**Our** R/2020/6/C  
**reference:**

**Your** SSD 10437 MOD 1  
**reference:**

**Subject:** Advice on Modification - Waterloo Metro Quarter OSD - Southern Precinct Detailed Design - SSD 10437 MOD 1

Figure 13 | Proposed ground floor landscape plan

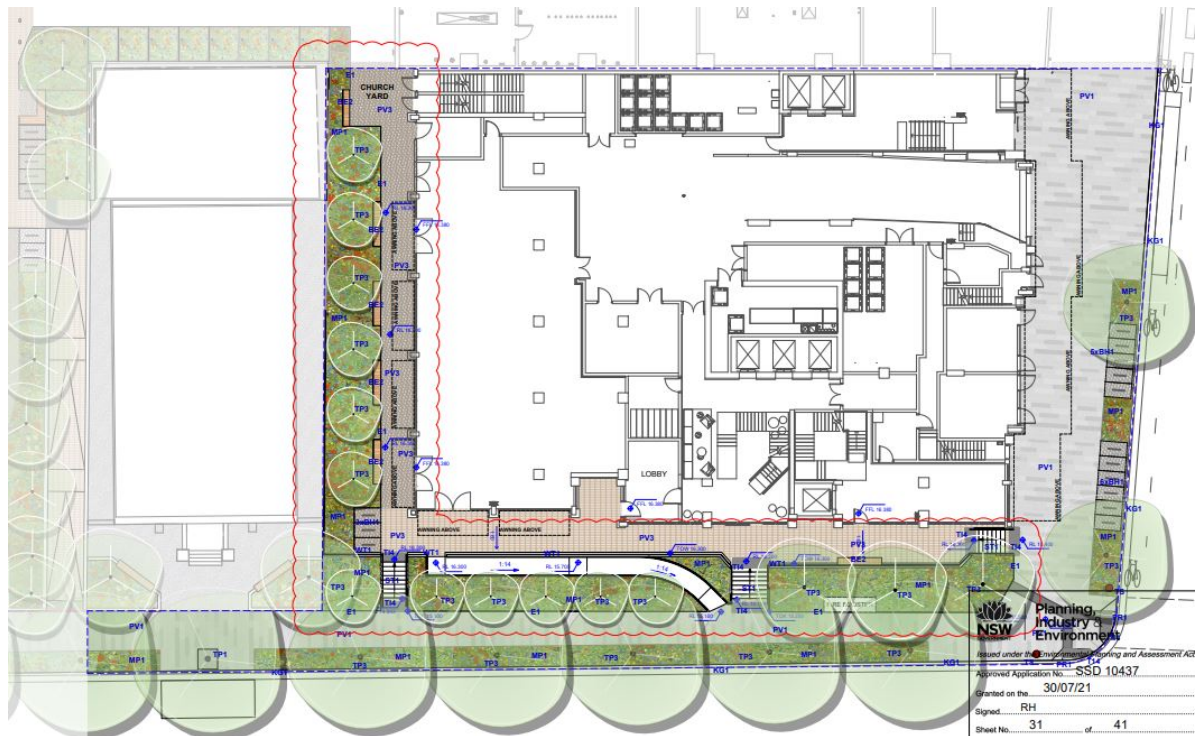
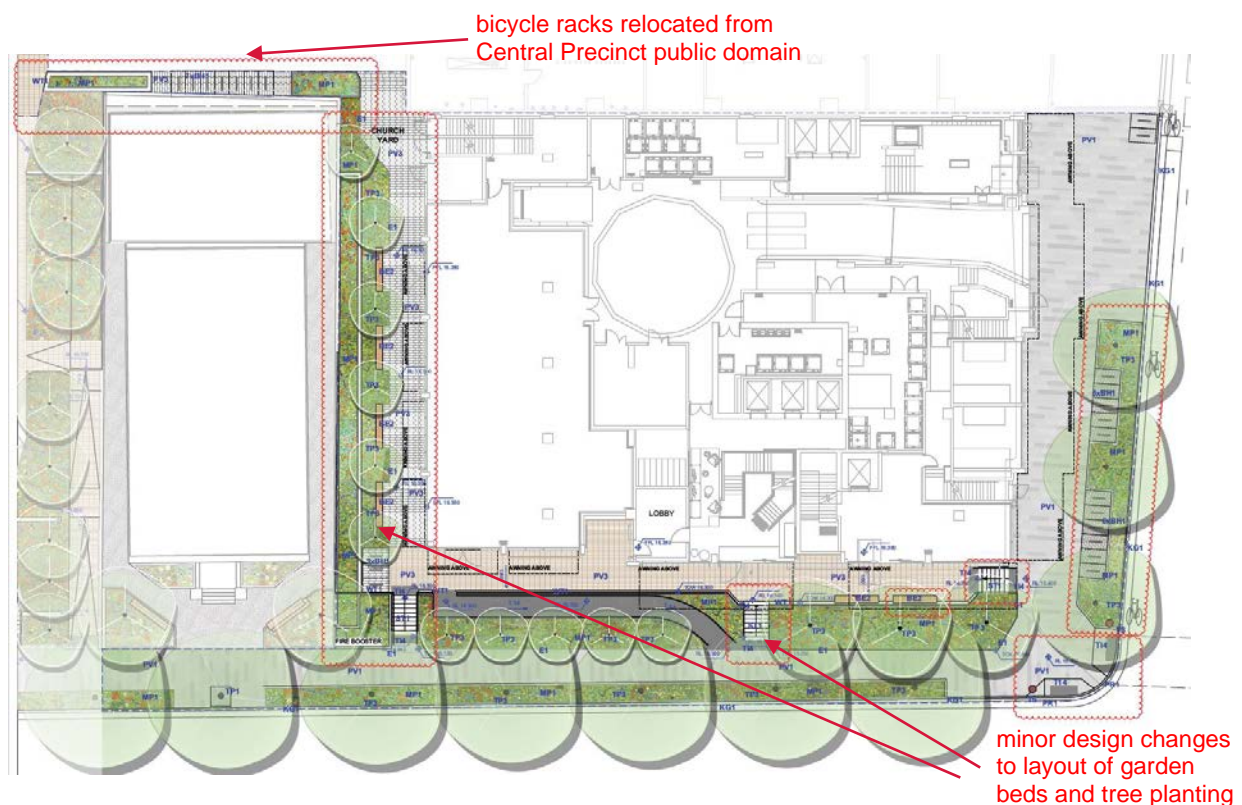
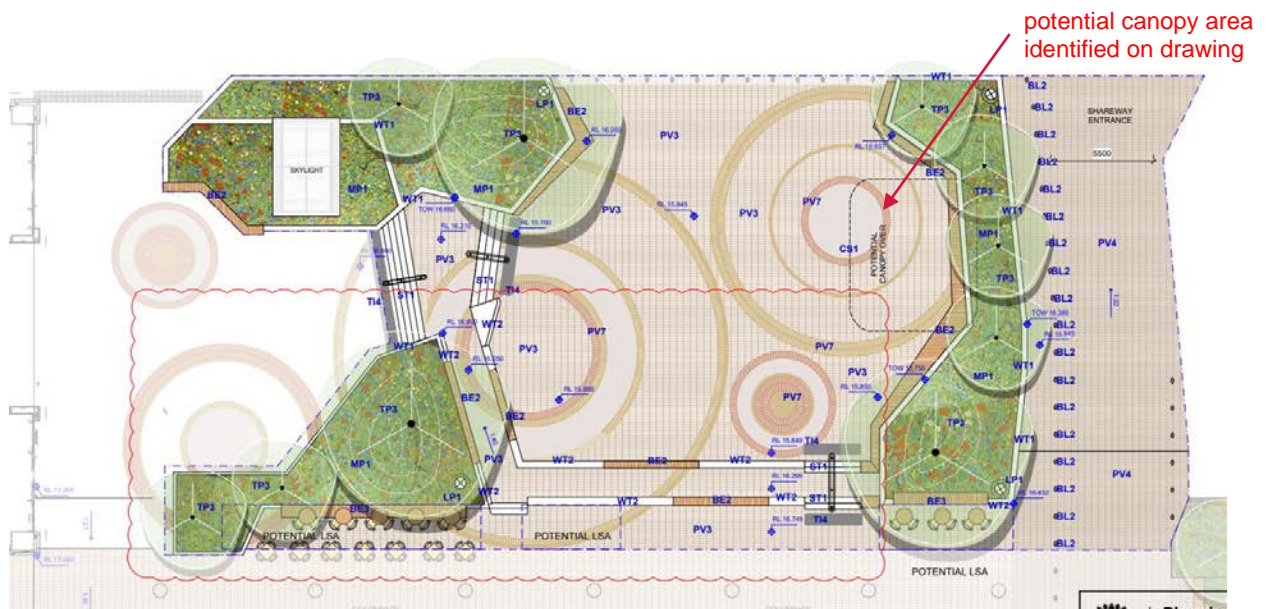
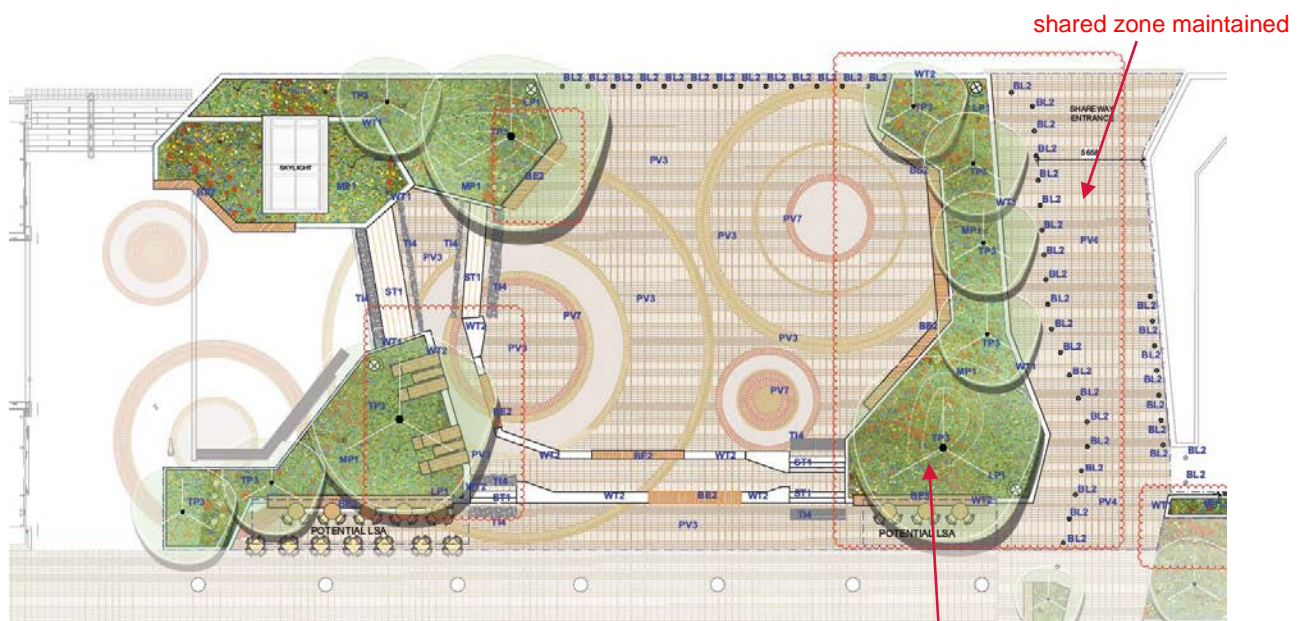
Further, the proposed design modifications preference the inclusion of bicycle racks in planters relocated from the central precinct, removal of shade (pergola) in the Cope Street Plaza, a vehicular access road promoted as a “shareway” from Cope Street to Church Yard that simply provides access to Building 2 parking spaces and removes tree planting to the Building 3 Level 2 communal open space terrace, due to structural constraints, reducing available shade for residents. Council stresses that as this project is a significant new development, allowances should be made for structural slabs and wet soil loads to provide shade to residents communal open spaces.

Overall, the proposed design modifications are a dilution of the previously approved landscape plans and result in a reduction in landscape quality of private and public spaces. We reiterate that it is disappointing that the City were not consulted on the detailed landscape plans and landscape conditions prior to approval.

Although not specifically not proposed in this application, your attention is drawn to the current design of the public domain along Cope Street. The submitted plans show a garden bed extending the entire width of the Council-owned footpath while pedestrians will be directed onto private land to travel safely along the street. While the formal public domain plans are under consideration by Council, it is important to flag the issue of land ownership and pedestrian access around the site whilst the modification is under assessment. For many reasons including public liability, it is not recommended to have a garden bed obstructing the entirety of the footway, however, where the landscaping design in its current proposed form is supported, it is recommended that the following condition be imposed.

DRAWING
LANDSCAPE PLAN
LEVEL 02 COMMUNAL TERRACE

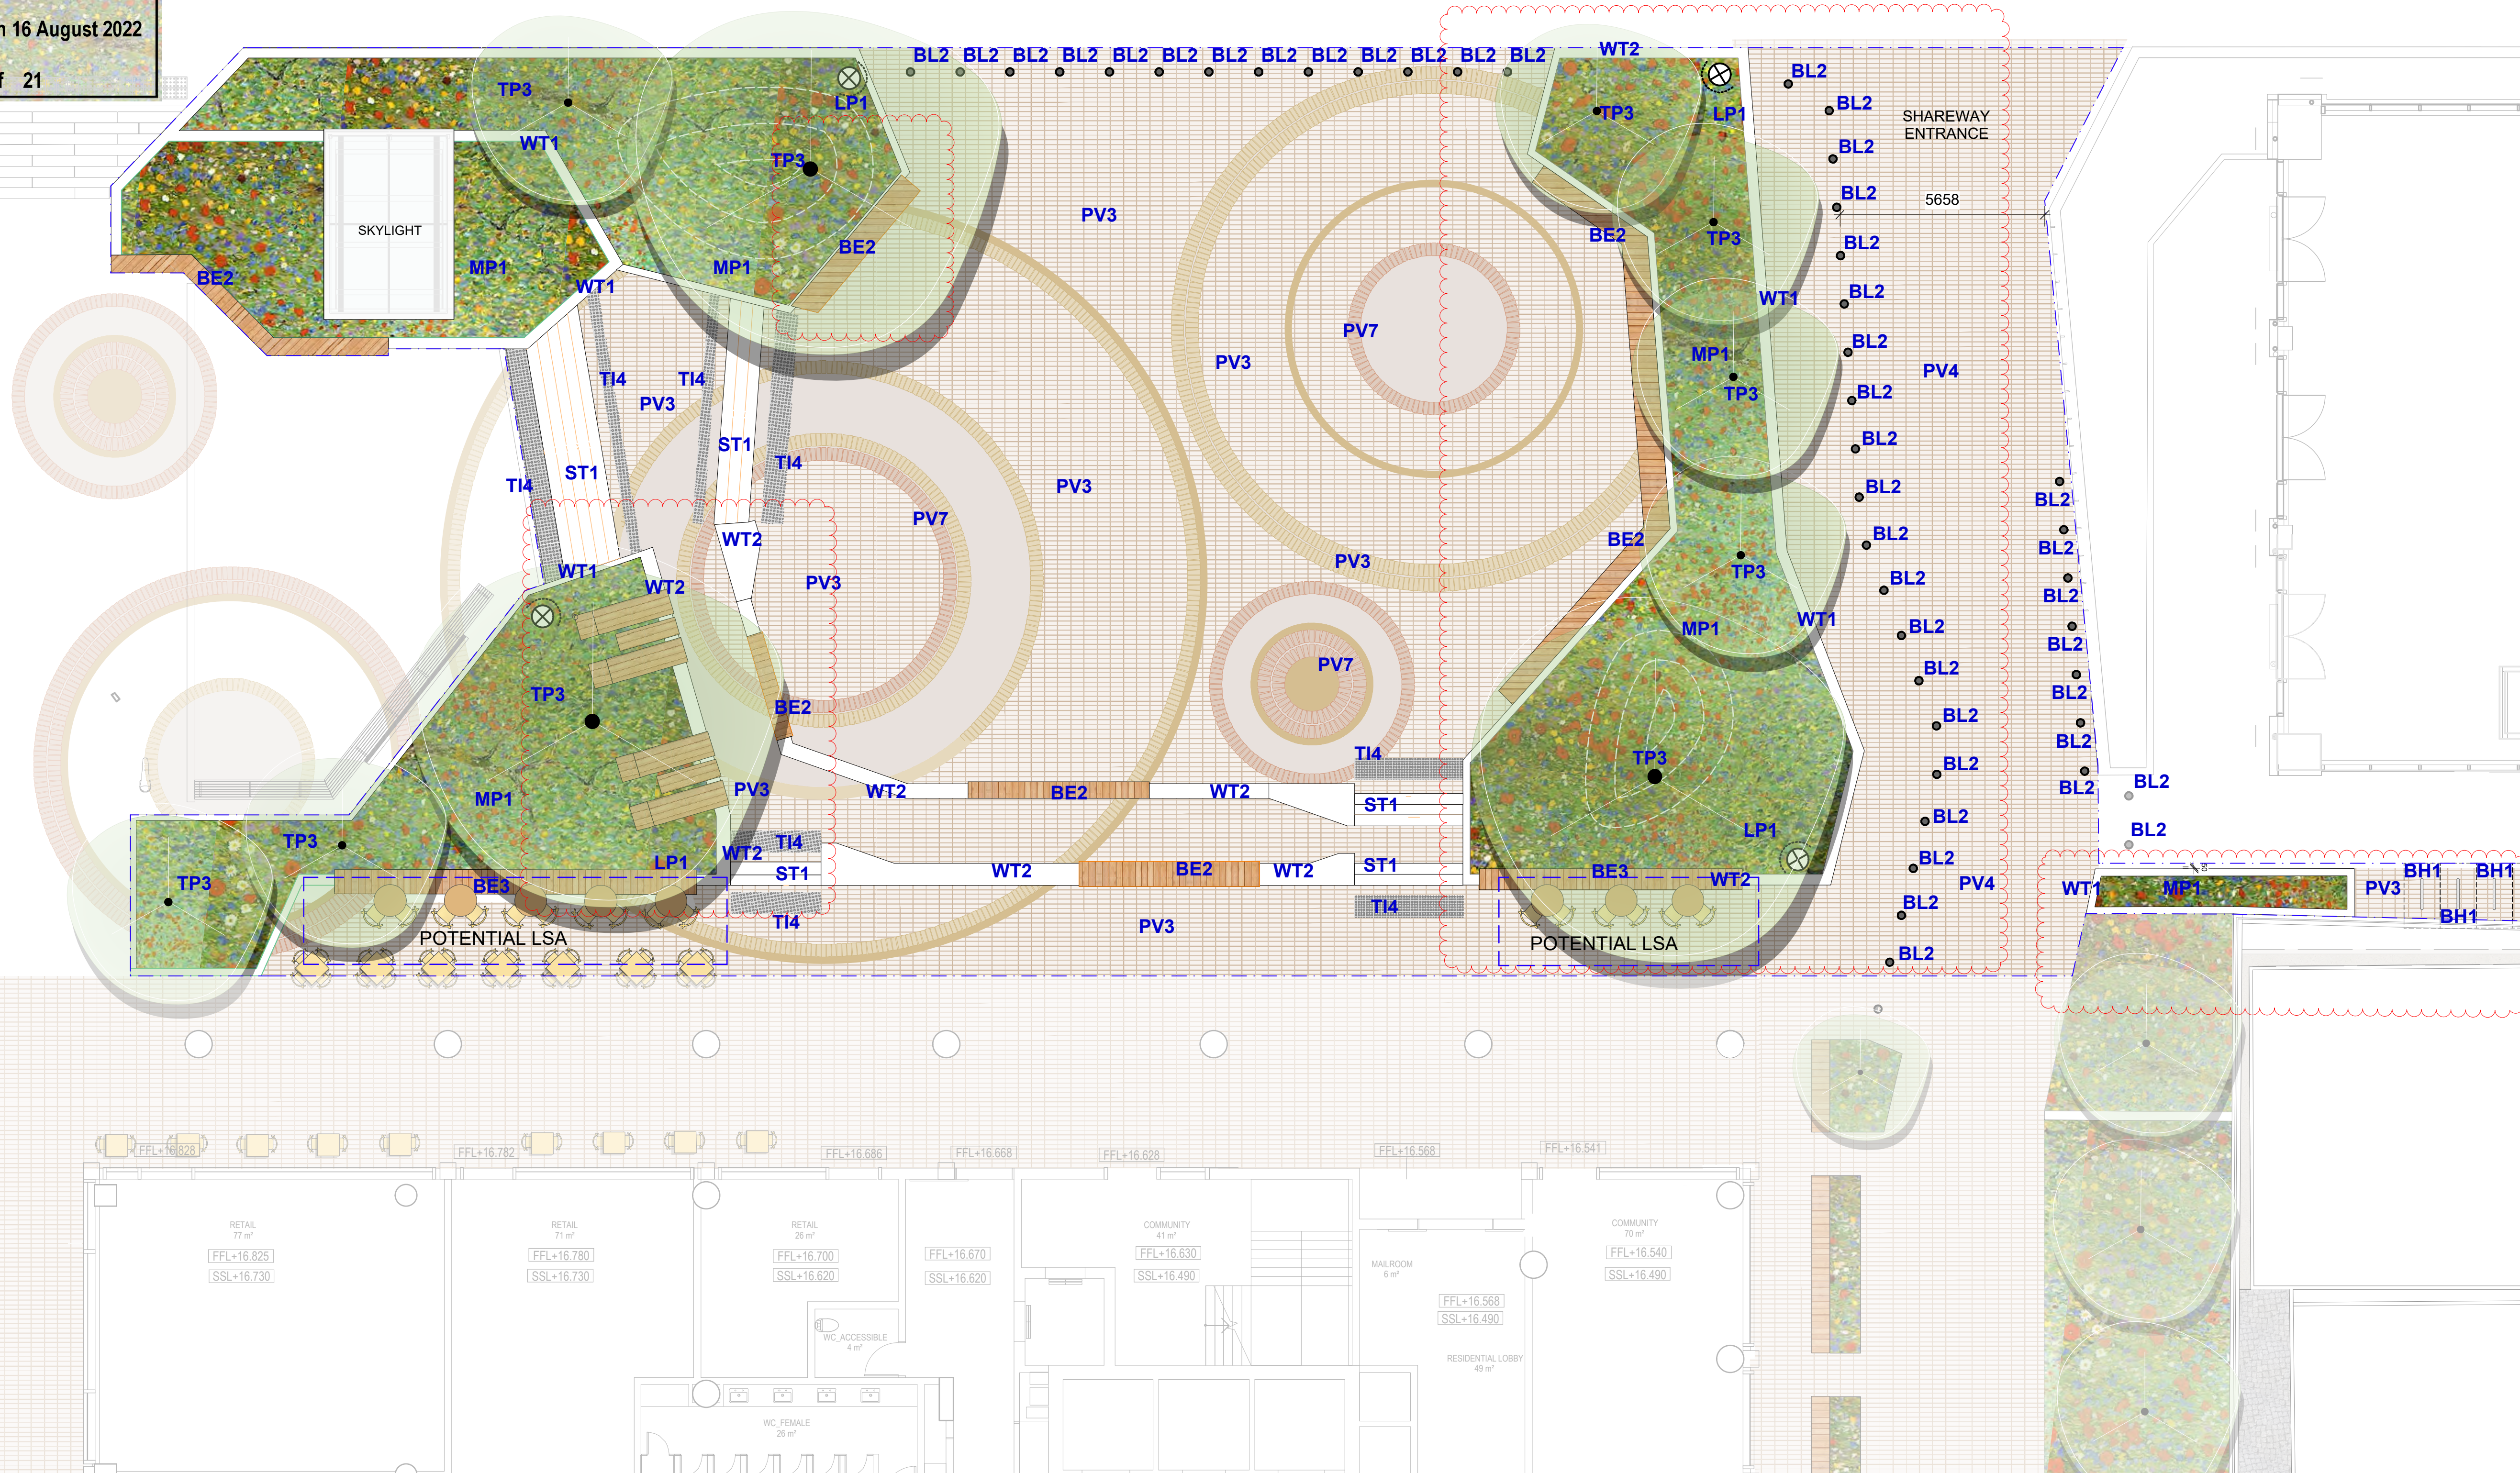
Additionally, there has been no amendment to the Building 3 Level 3 green roof plan to make allowance for minimum soil depths, increased edge and allowance for drainage. Nor has there been any increase in green roofs across rooftops in the precinct.
